**SOPA SITE 3
AUSTRALIA TOWERS**

S75W ACCESS REVIEW

Morris-Goding Accessibility Consulting

20 June 2012

Site 3
Sydney Olympic Park
Plan
Basement 001

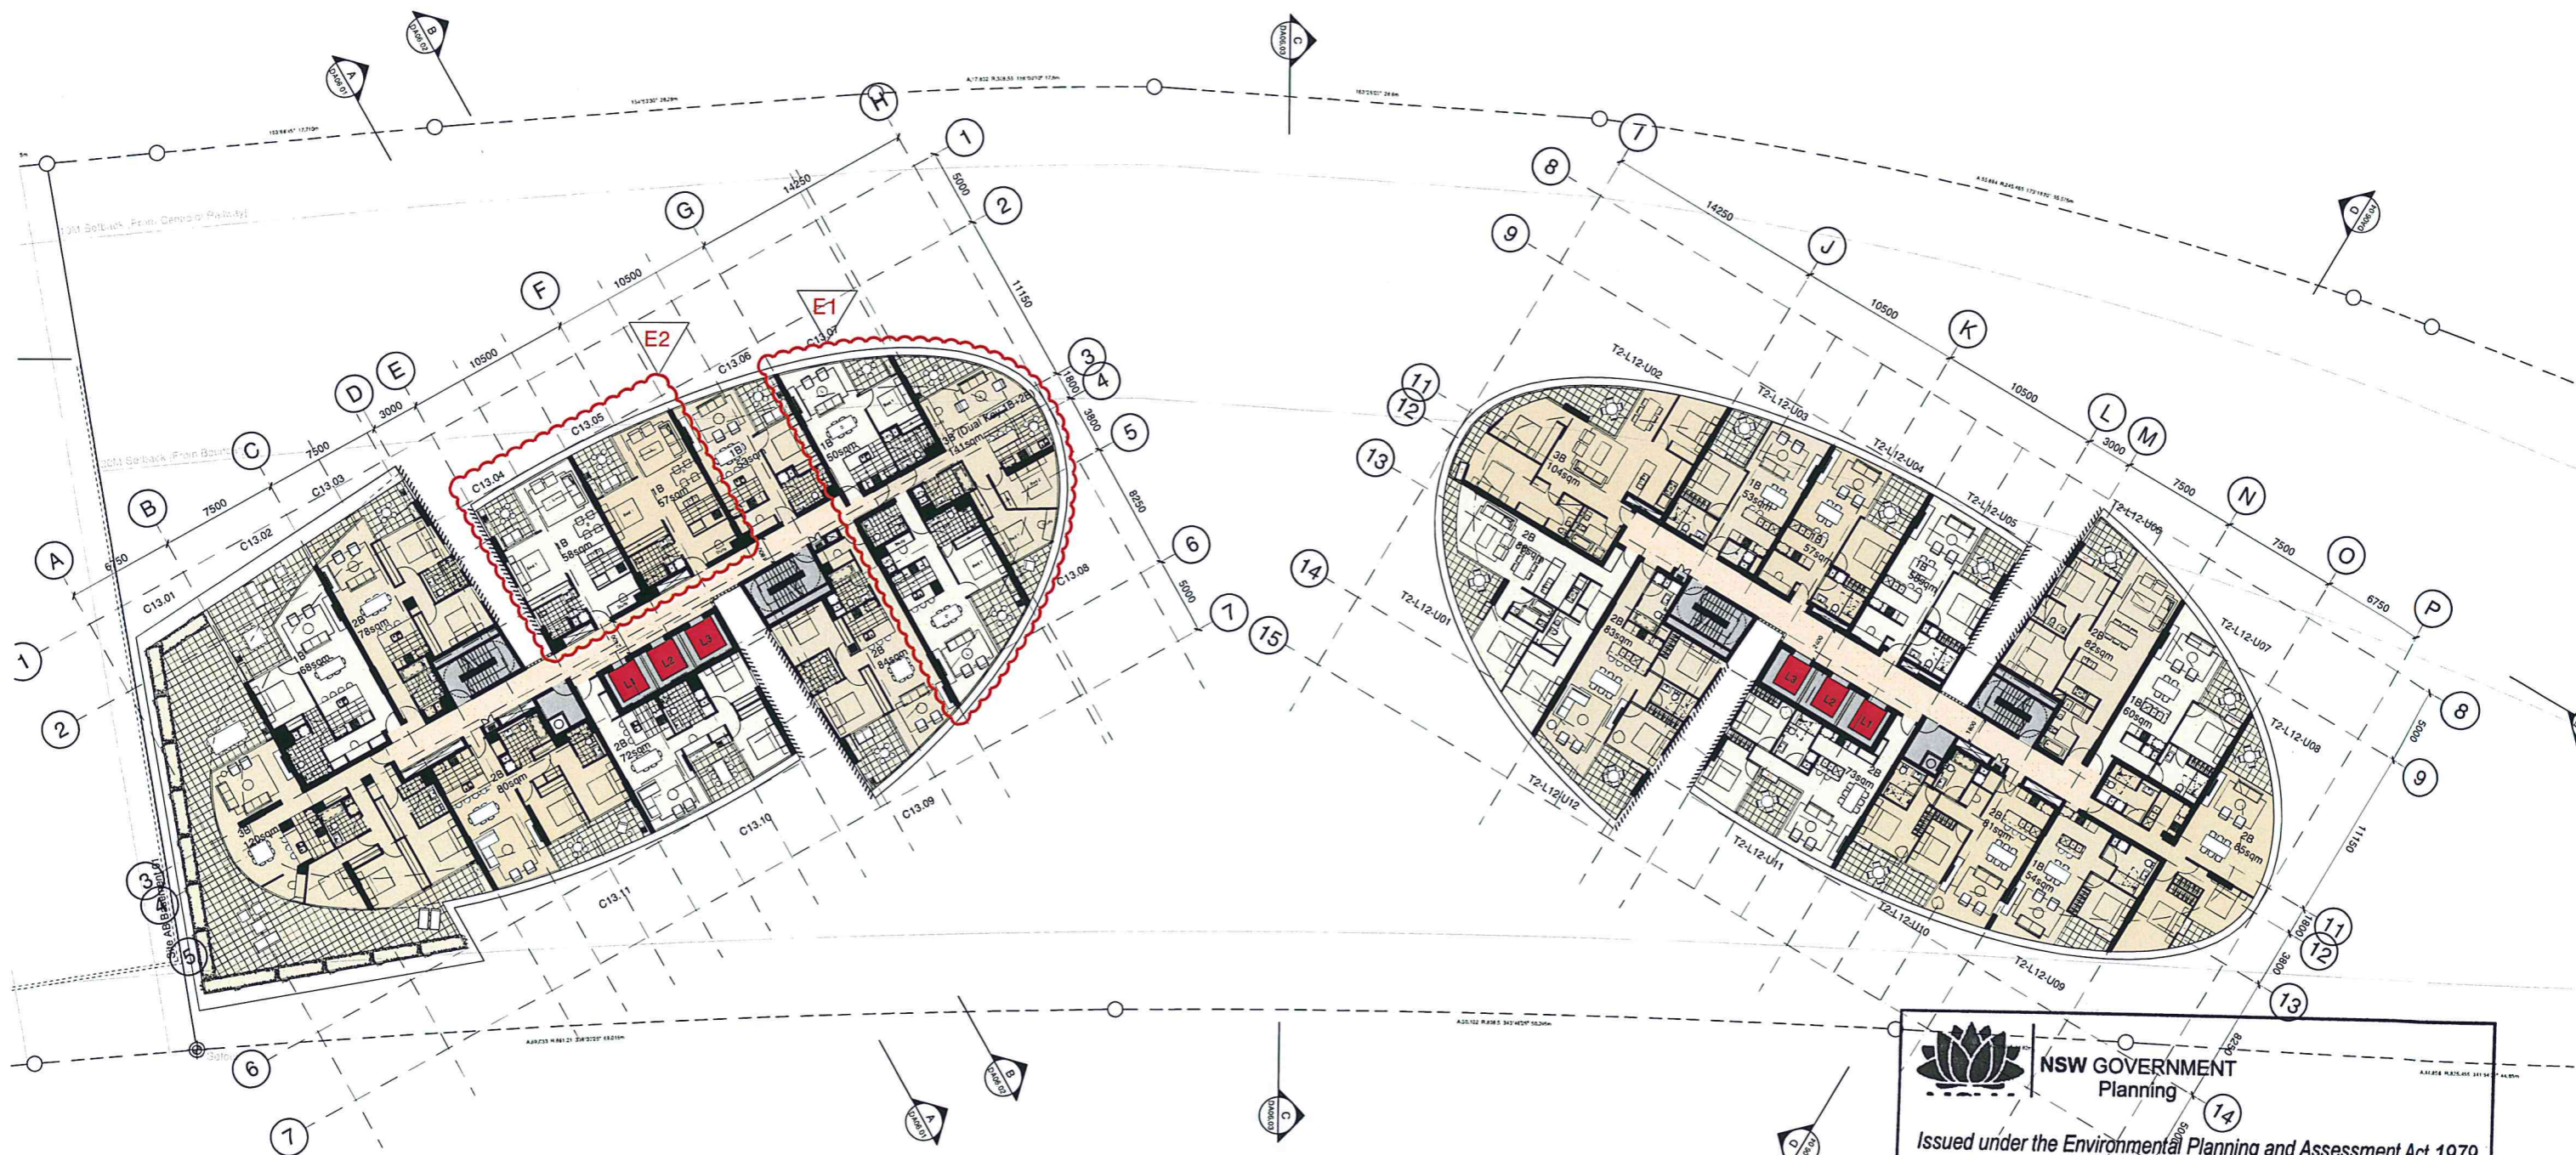
From the ground floor car parks, entry to the lobby areas is via corridors with 1600mm clear widths suitable for a person in a wheelchair to perform 180° turns in accordance with AS1428.1:2009. The doors have suitable minimum 880mm clear widths suitable in accordance with AS1428.1:2009. From the accessible car bays, a clear accessible path of travel to the lift lobby is required. Access currently is impeded by car parking columns and car bays. A suitable accessible path of travel is required.

- (i) Provide appropriate circulation area and access around the door that interfaces between corridor access (to lift lobbies) and the ground floor carpark area. It is advised that a shared zone be located in front of this door.

- (i) All adaptable car bays require a height clearance of 2.5 metres compliant with AS2890.6 and SOPA Access Guidelines.
- (ii) The approach to each adaptable car parking bay should have vertical clearance of not less than 2.2m in accordance with AS2890.6.
